1 Introduction

JMT Consulting has been commissioned by Atlassian (the Applicant) to prepare this document in response to the issues raised in by government agencies, community organisation groups and the public during the public exhibition of the proposed Atlassian Central State Significant Development (**SSD**) application (SSD-10405) in relation to the site at 8-10 Lee Street, Haymarket.

This document has been prepared to respond to the transport related issues raised by Transport for NSW and City of Sydney Council as reproduced on the following pages.

DIVE RAMP SECTION

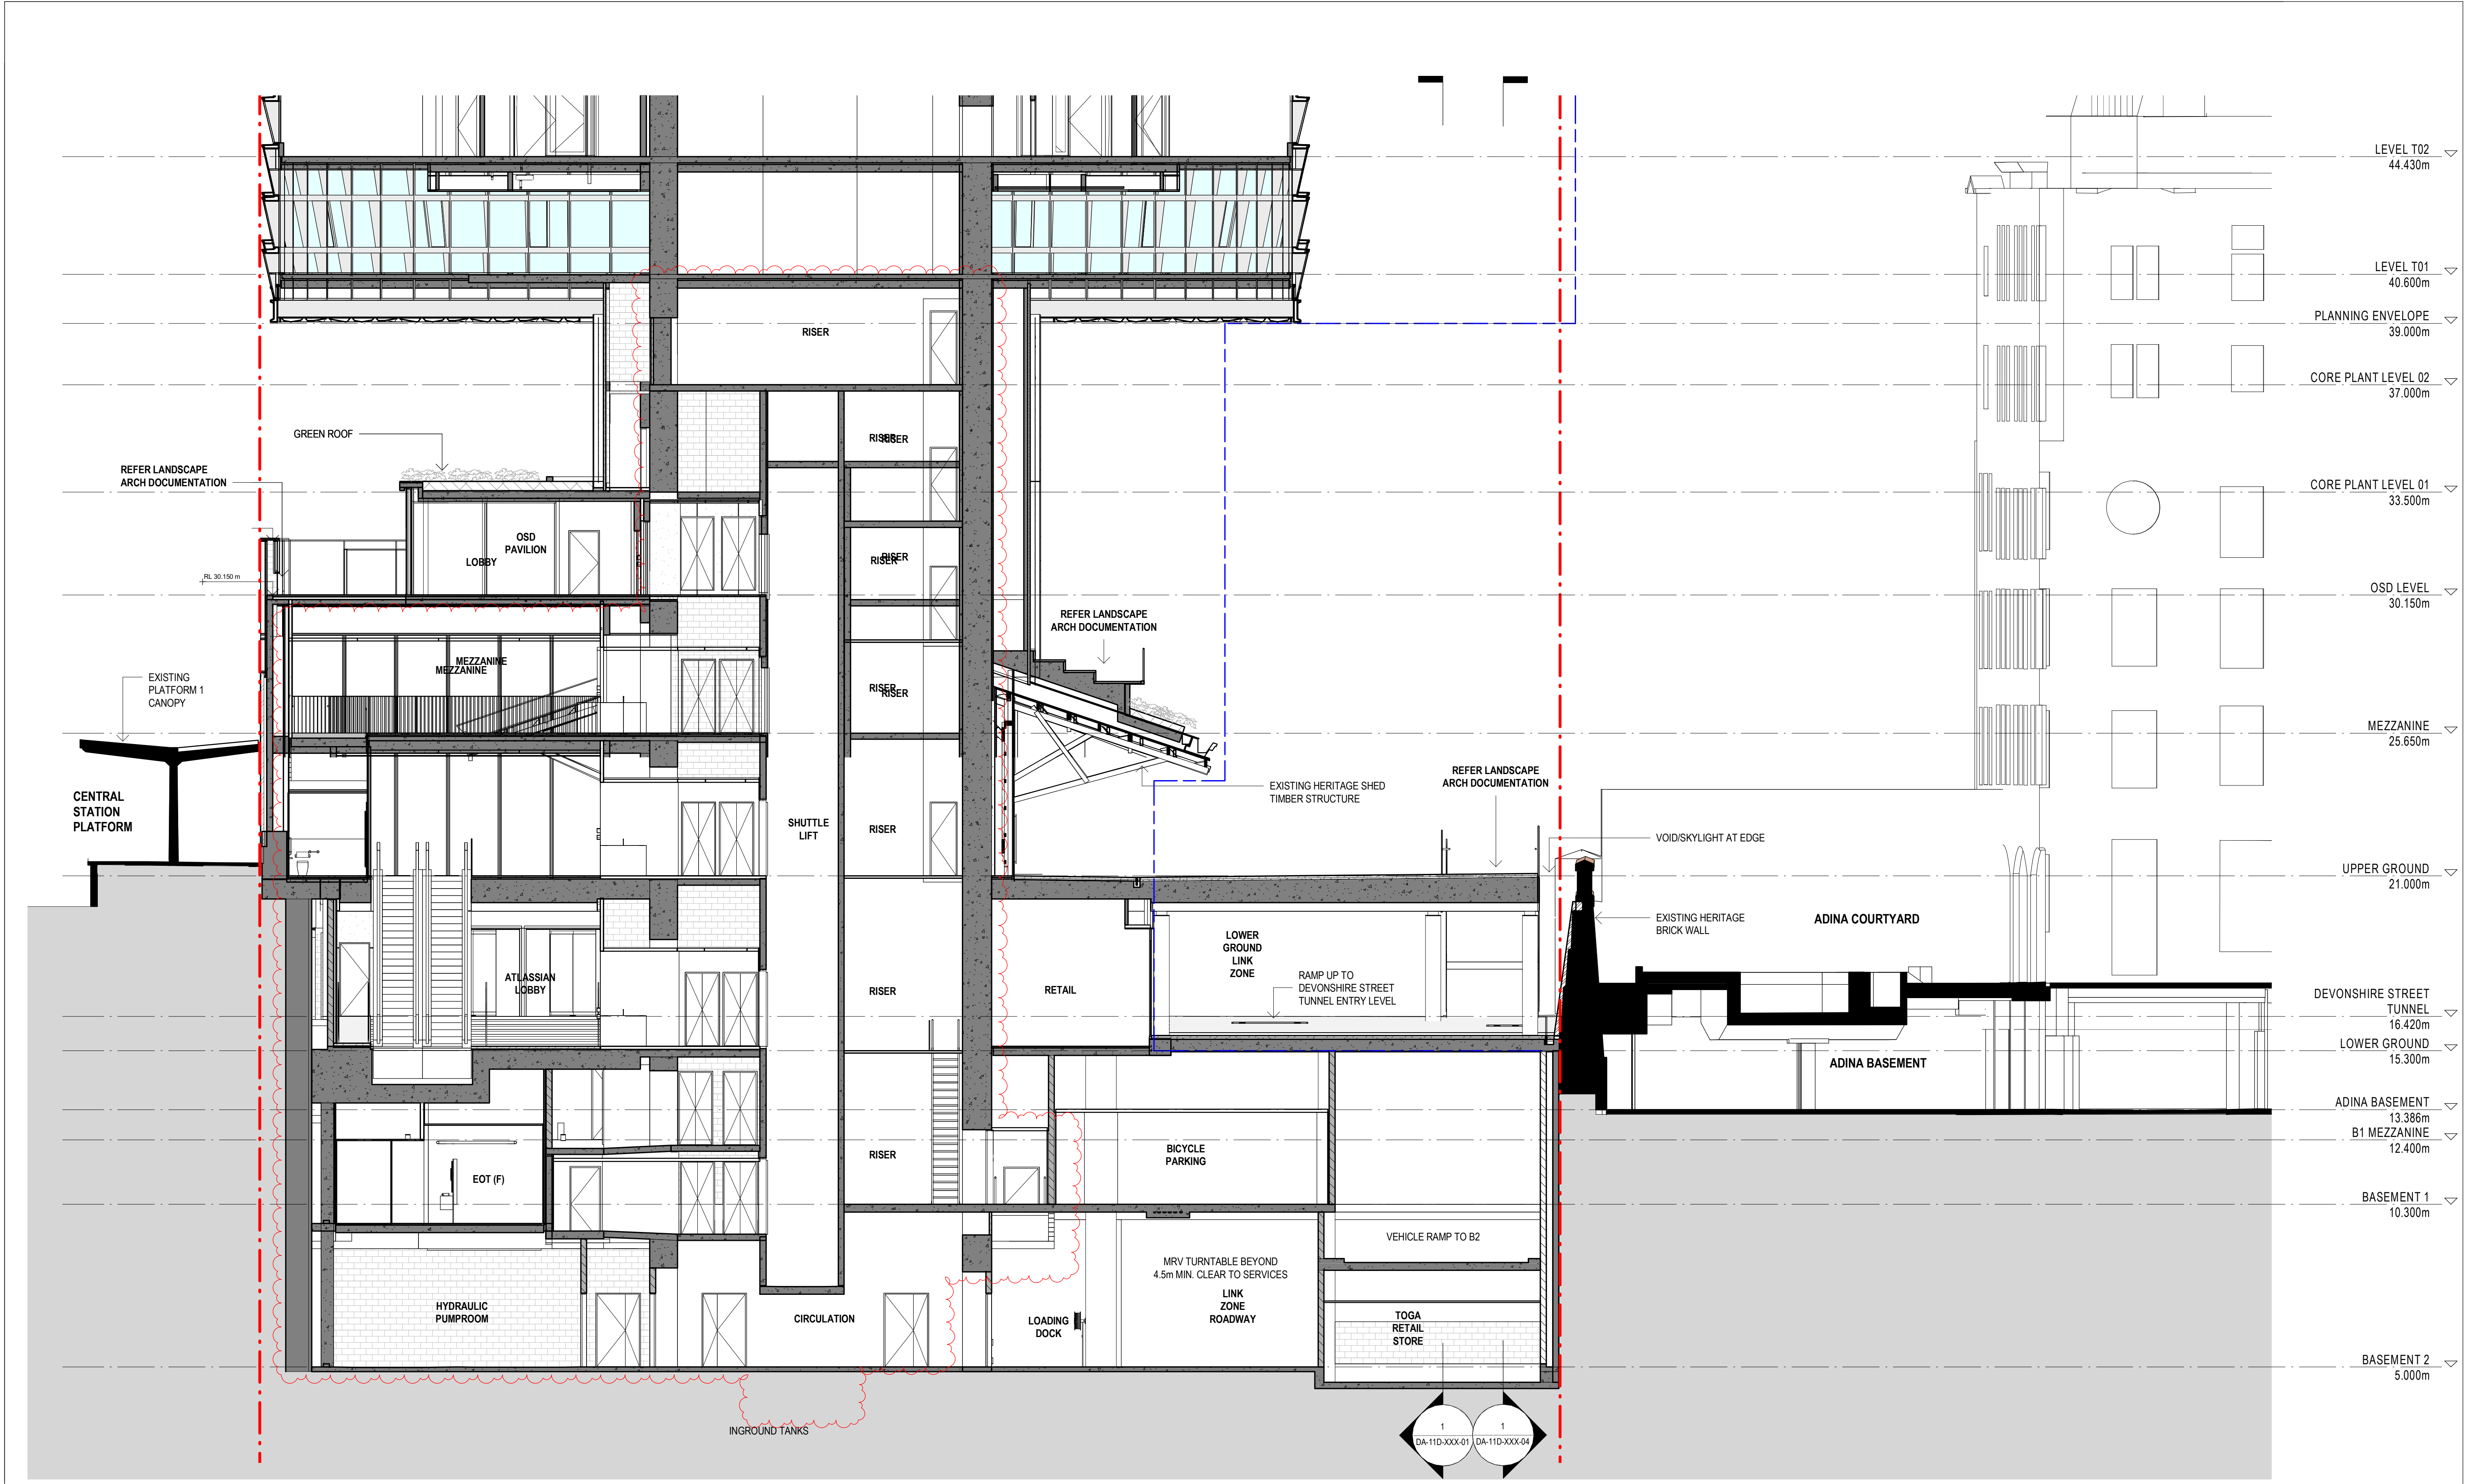
City of Sydney Council Submission	JMT Consulting Response
The application proposes a 3.6 metre clearance for the service vehicle ramp access. Please note that MRVs require 4.5 metre clear height and will have a maximum length of 8.8 metres. It is recommended that the ramp be amended accordingly.	The vehicle access ramp into the Atlassian building has been designed by JMT consulting to have the steepest possible ramp slope of 1:6.5, as per the Australian Standards requirements. As a result the lowest achievable RL for Level B2 is RL 5.0 which allows for the maximum possible height at the southern boundary connection. This ramp cannot be extended any further due to the turntable is at the bottom of the ramp. With the Sydney Water easement clearance zone a maximum clearance height of 3.6m for vehicles can be achieved which would be an extension of the dive ramp height. It is important to note that while a 3.6m clearance height is provided in the 'Day 1' scenario, suiting the specific needs of Atlassian, a 4.5m clearance height is provided in the 'Day 2' scenario which satisfies the requirements of all stakeholders in the Western Gateway precinct. A 4.5m clearance height for a Medium Rigid Vehicle (MRV) is noted in Table 2.1 of Australian Standards for off-street commercial vehicle facilities AS2890.2 2018. In relation to this clearance height the following should be noted: • The reference to a 4.5m clearance height is based on specifications a document from 1995 that has since been withdrawn • The standard notes that there is provision for a variation in the dimensions when a commercial facility is being designed specifically for a nominated vehicle type. The Atlassian Central development dive ramp structure via Lee Street has been designed to provide a 3.6m clearance height which will initially service the on-site loading dock, prior to the completion of the Dexu/Frasers Site. Given the constraints associated with the Sydney Water asset above the B2 access tunnel, a 3.6m height clearance to service the Atlassian Central development would be considered acceptable. As indicated in the table below, there are

A 3.6m height clearance provides flexibility for a large range of Medium Rigid Vehicle's including waste contractor vehicles with a lifting capacity of over 600kgs and payload of 8500kgs. An example of a large rear-lift waste contractor vehicle with a clearance of less than 3.6m is shown in the figure below.
